CITY OF ALBUQUERQUE

RE: **Juan Tabo Hills Estates**
Revised Grading Plan
Engineer's Stamp Date: 7/12/18
Hydrology File- M21D018; DRB# 1005278

Based on the submittal received on 7/20/18, the revised grading plan cannot be approved until the following are corrected:

GRADING & DRAINAGE PLAN

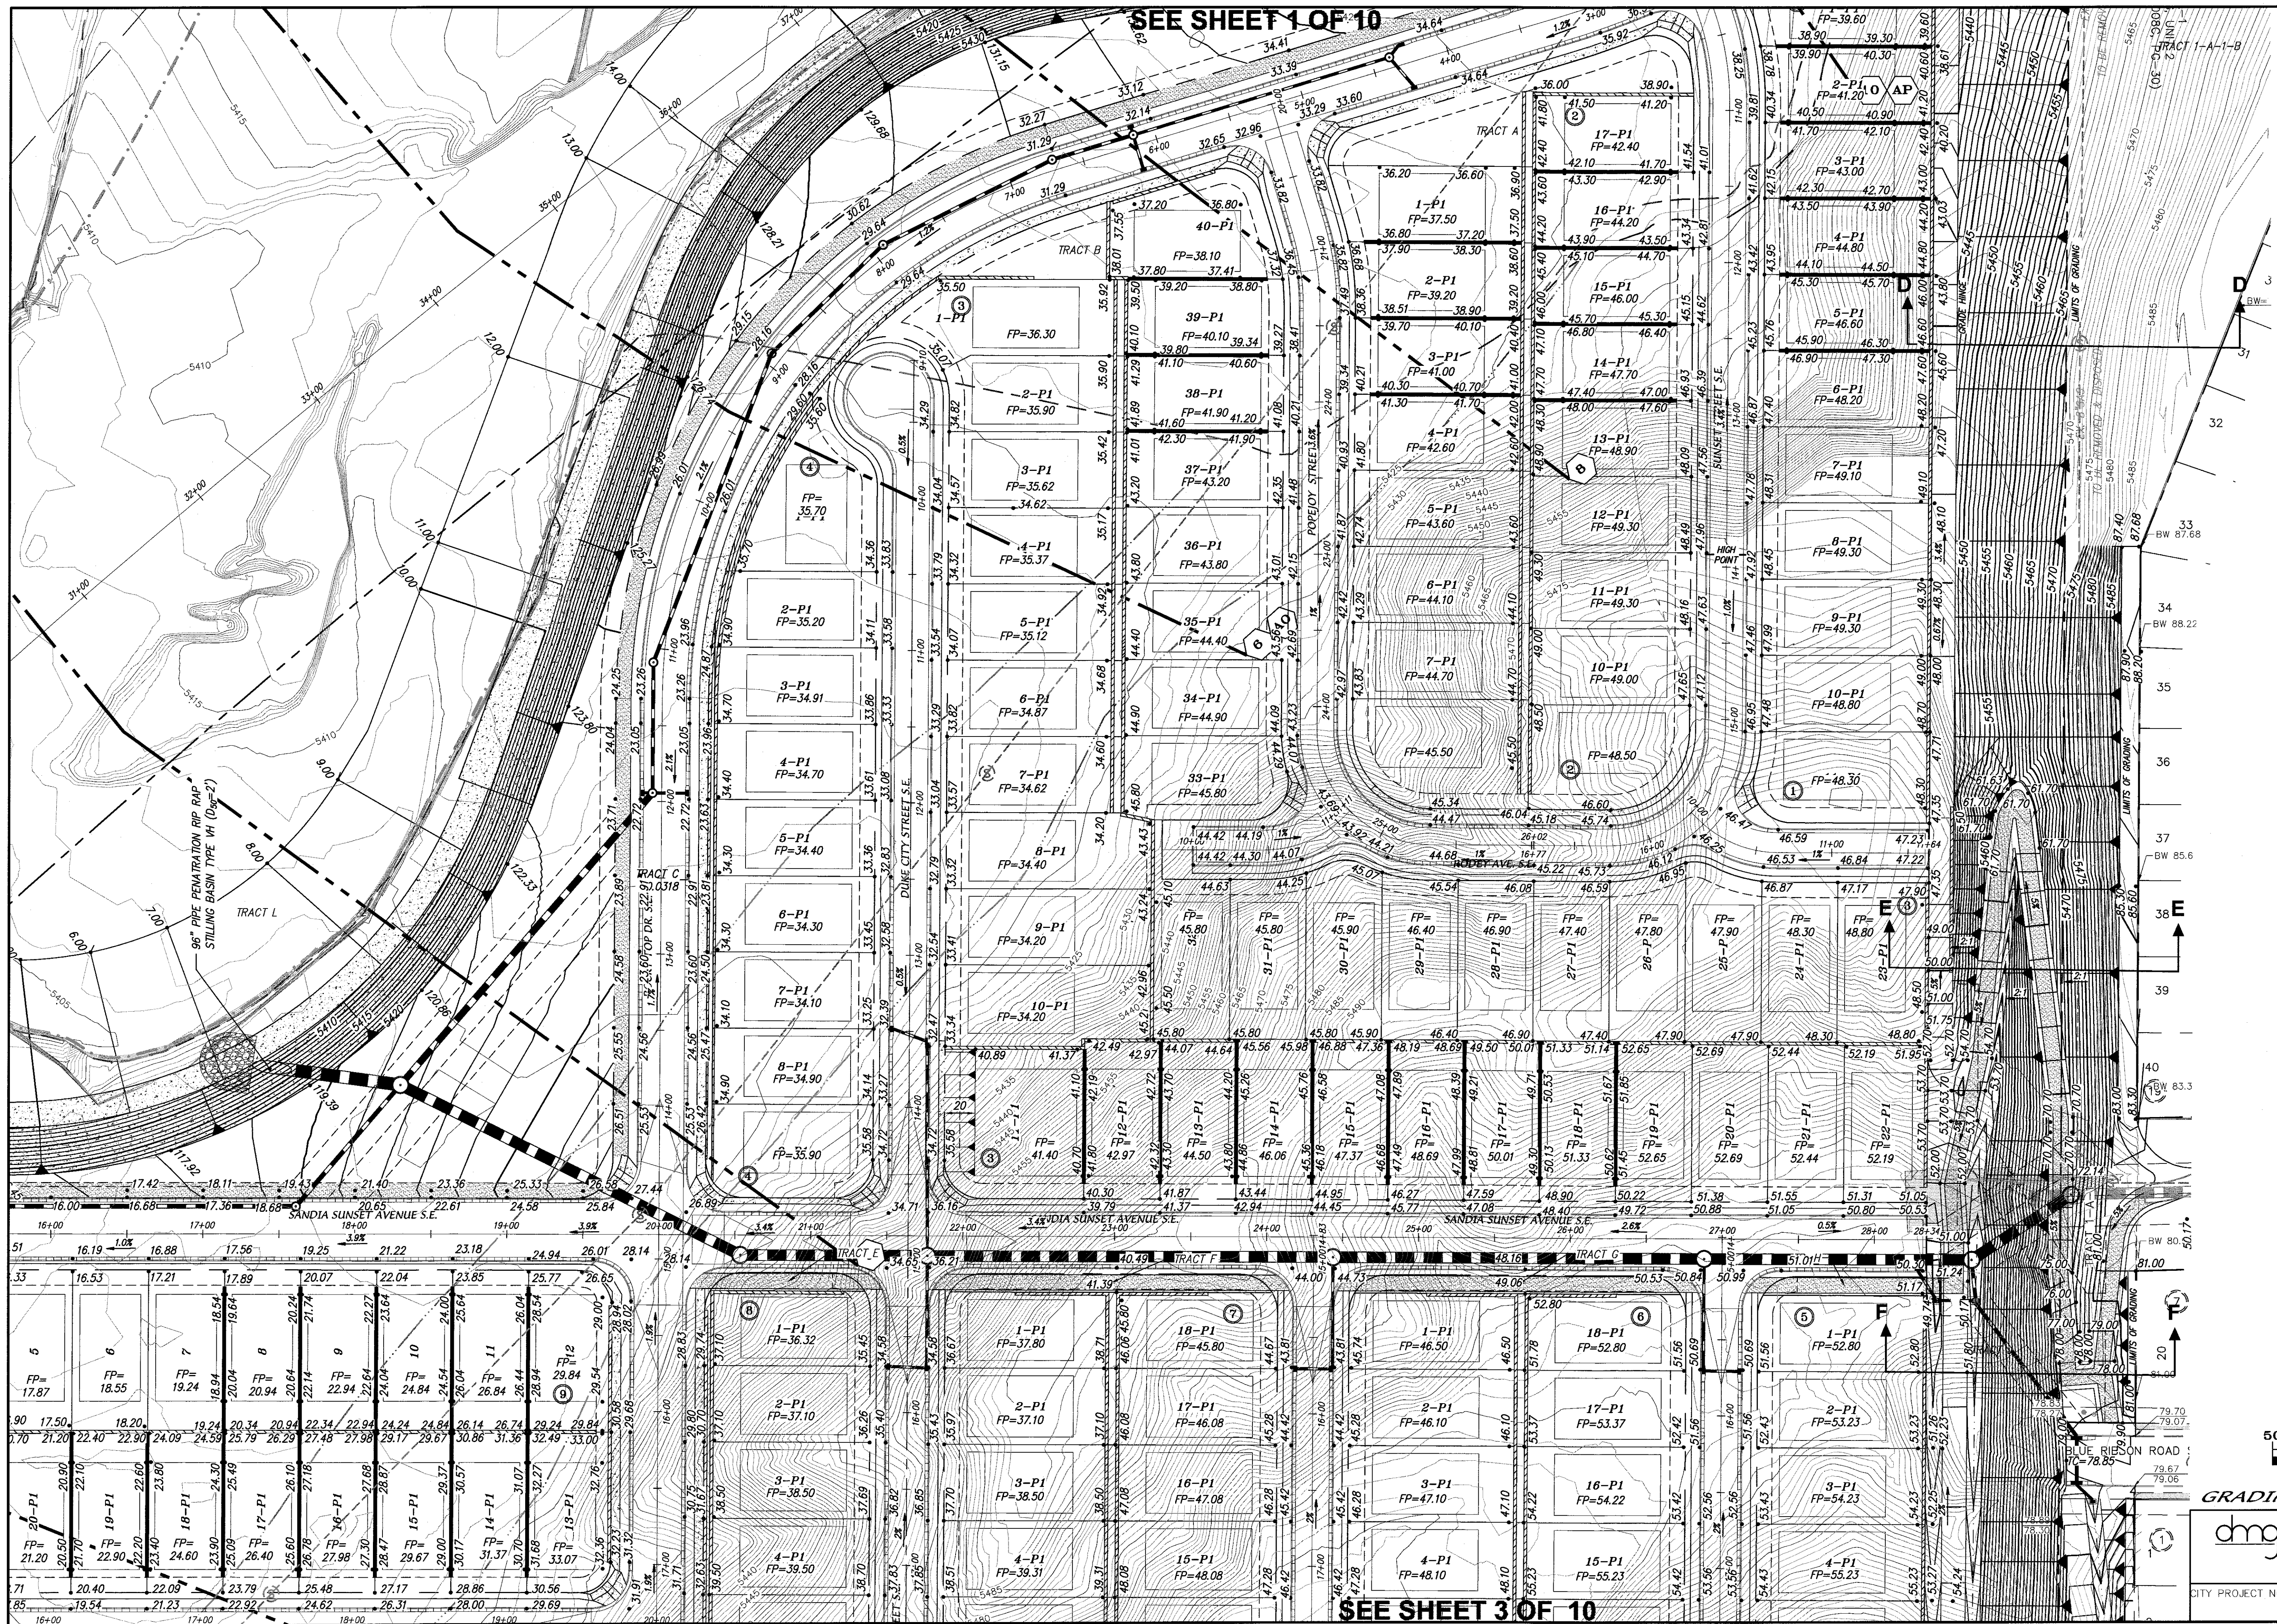
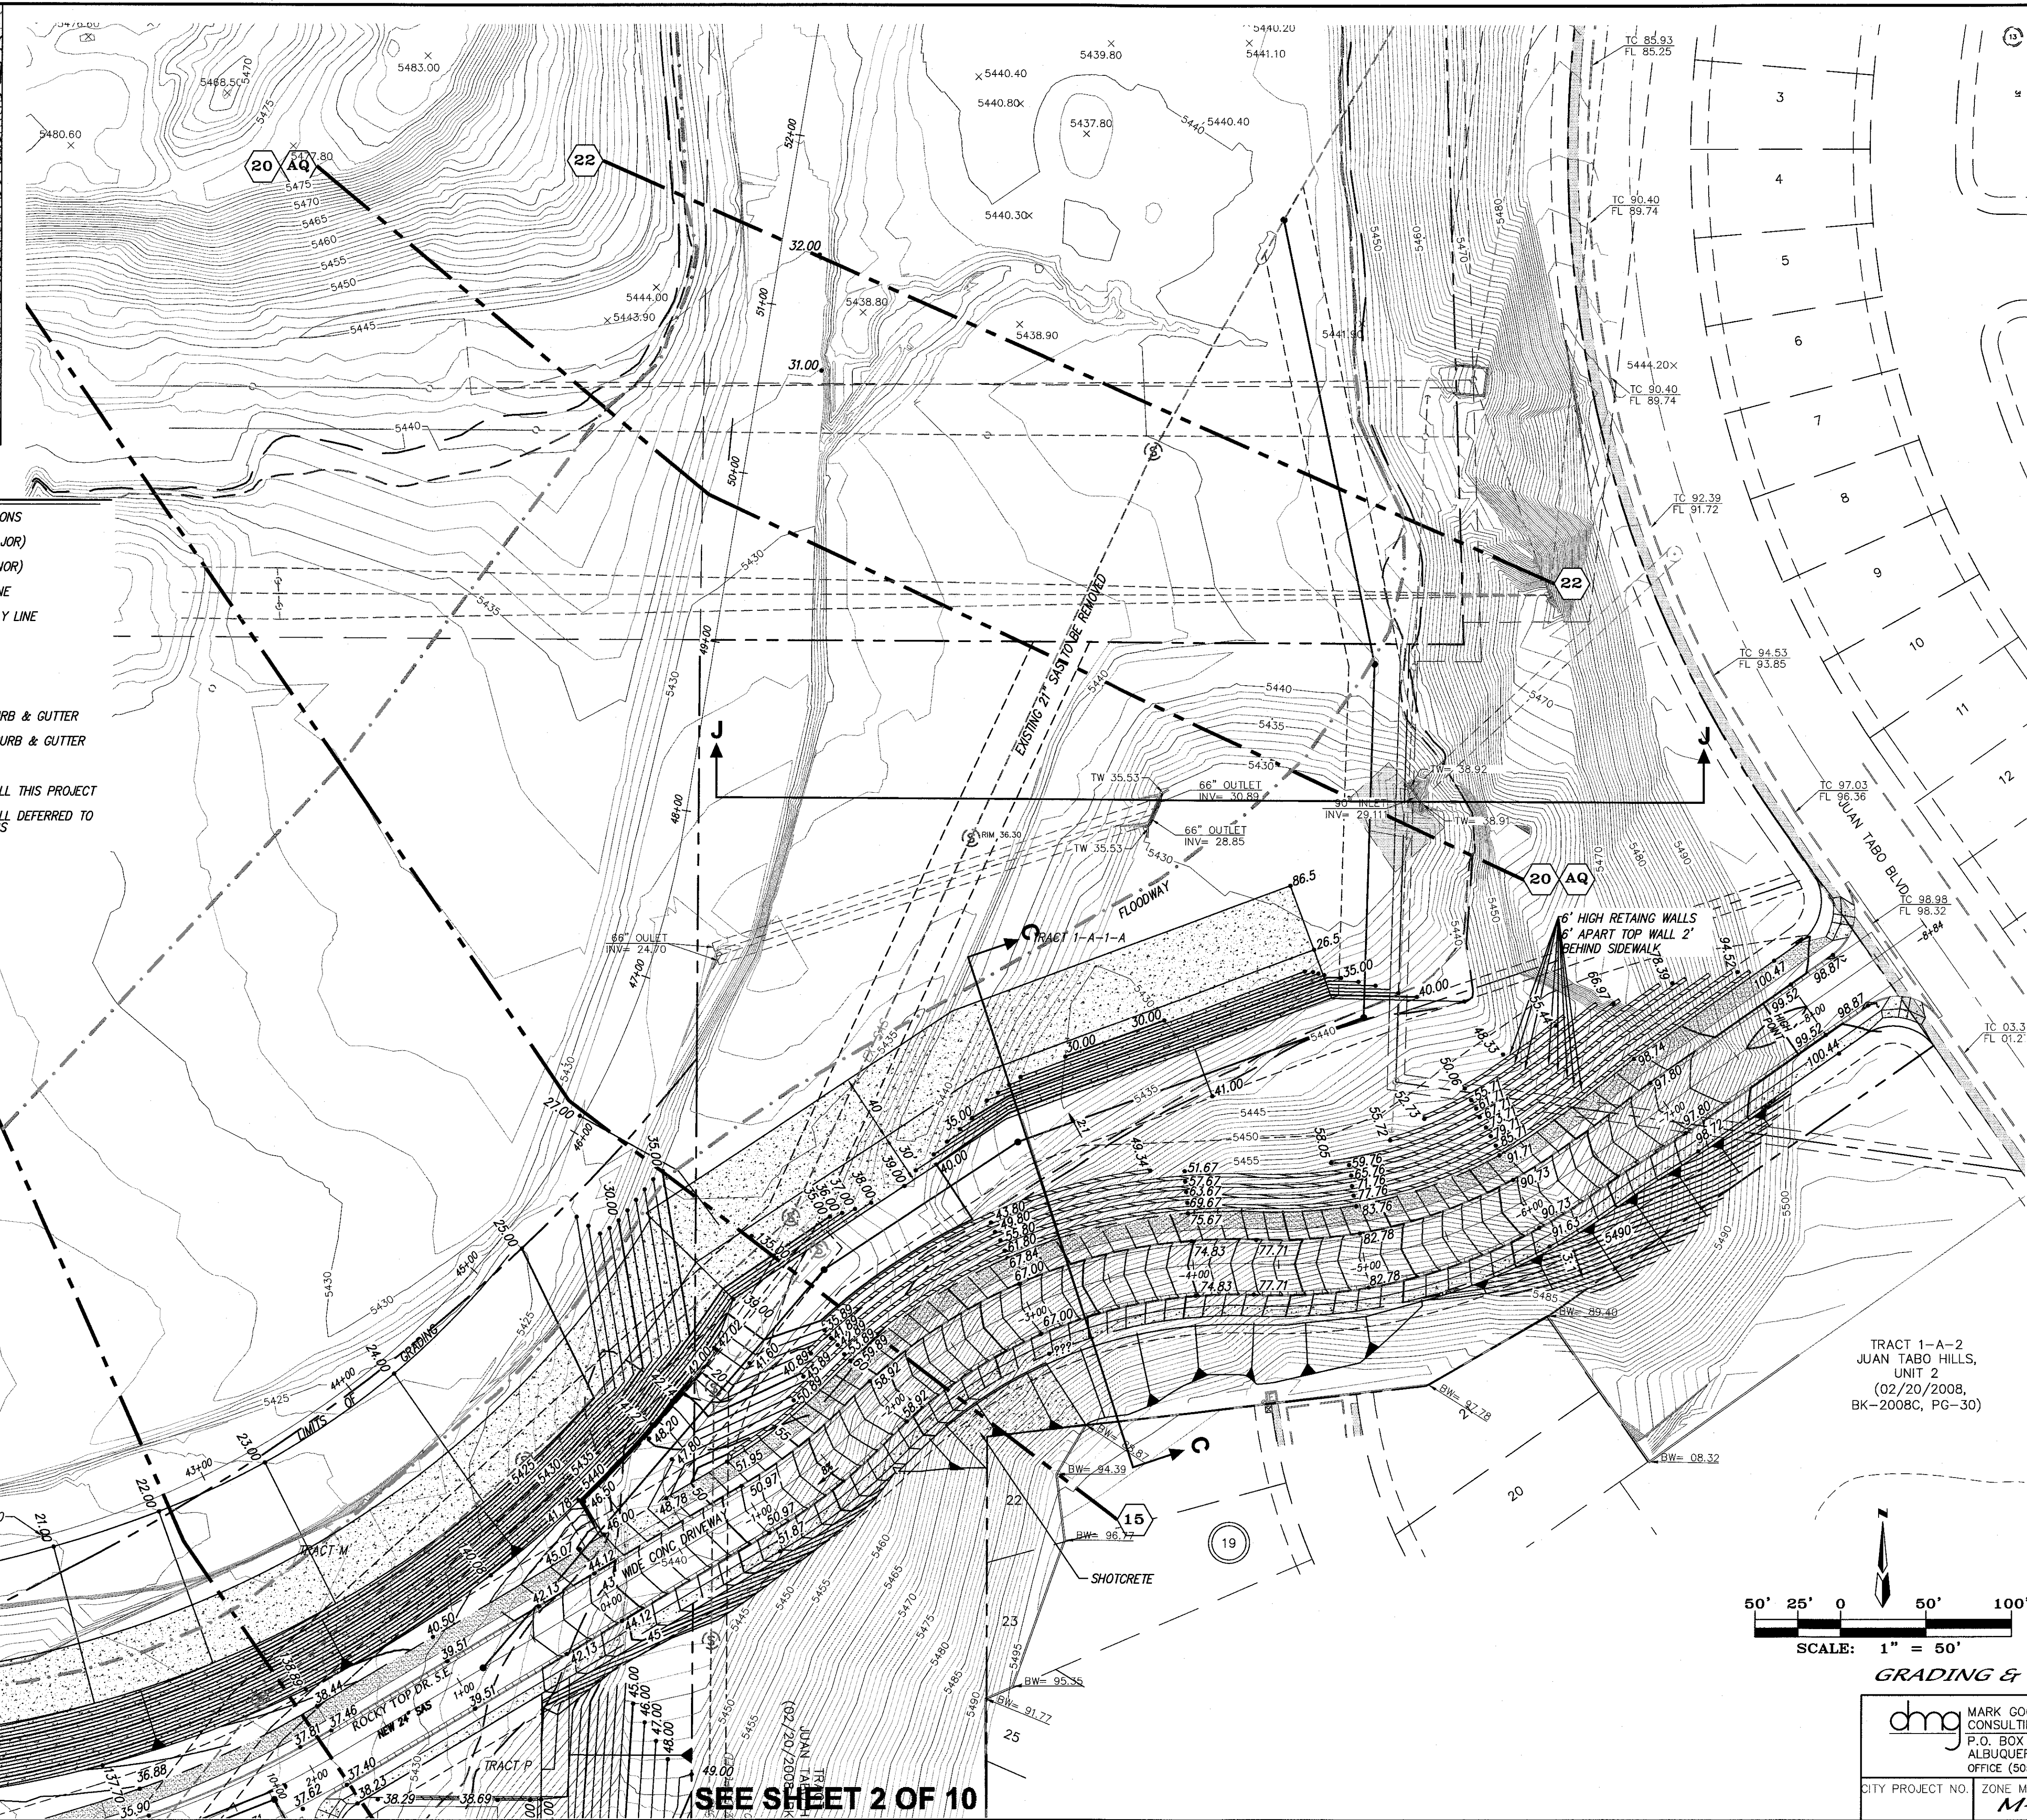
1. Fill in or provide an armored drainage conveyance for the low spot south of the Rocky Top entrance. This area cannot be allowed to pond adjacent to the road embankment:

2. Provide the sections shown on the grading plan.
3. Provide an armored drainage conveyance for the interspaces between the terraced retaining walls and down into the storm water pond; ensure the AMAFCA access road is protected from this runoff:

4. Please verify that the AMAFCA maintenance ramp, gate, and retaining walls are consistent with the current bank protection plans:

5. Provide self-ponding areas in the interspace (park) between the AMAFCA access road and the public road. The contours and spot elevations should reflect the access road as sloping at 2% away from the top of shotcrete and back into the park area. The ponding areas should be sized for the 10-day, 100-yr volume with supporting calculations provided.
6. This plan proposes lot adjustments and changes to the approved grades in excess of 18" and within 50' of the property line (vicinity Lot16, Block13). The amended preliminary plat will require Development Review Board approval (Hydrology approval of the revised grading plan will be a pre-requisite of the amended plat):

7. Many of the Lots have been re-numbered. Is this intentional? This will need to be updated on the amended preliminary plat as well. Look at: Block 19, Block 14, Block 13,
8. Lot 8(?) of Block 12 is not labeled. Lot 6(?) of Block 4 is not labeled. Lot 6(?) and Lot 7(?) of Block 2 are not labeled.
9. The pads for: Lot 1- Block 14, Lot 1- Block 15, Lot 16- Block 9, encroach into the ROW; please correct.
10. Explain the switch to the dual pipe penetration at the SW pond. Is this reflected in the bank protection plans? Where are its build notes? It is still labeled as a single 48" pipe. The grading for the AMAFCA access ramp should be shown here as well as the grades for the emergency spillway:

11. Will this pond still function as a first flush facility? If not, than payment of the Fee-in-Lieu will be required at a rate or \$6/cf for the SWQ volume.
12. Provide rip-rap armoring at the outside bend of Sandia Sunset. If water surcharges out of the NMDOT inlet upstream near MH-47, flows will travel overland down Sandia Sunset and will likely jump the curb at this bend:

13. Hydrology recommends putting the prudent line for the Tijeras Arroyo on this grading plan if desiring to obtain Pad Certifications prior to acceptance of the bank protection. Otherwise the prudent line will need to be added on each Pad Certification.
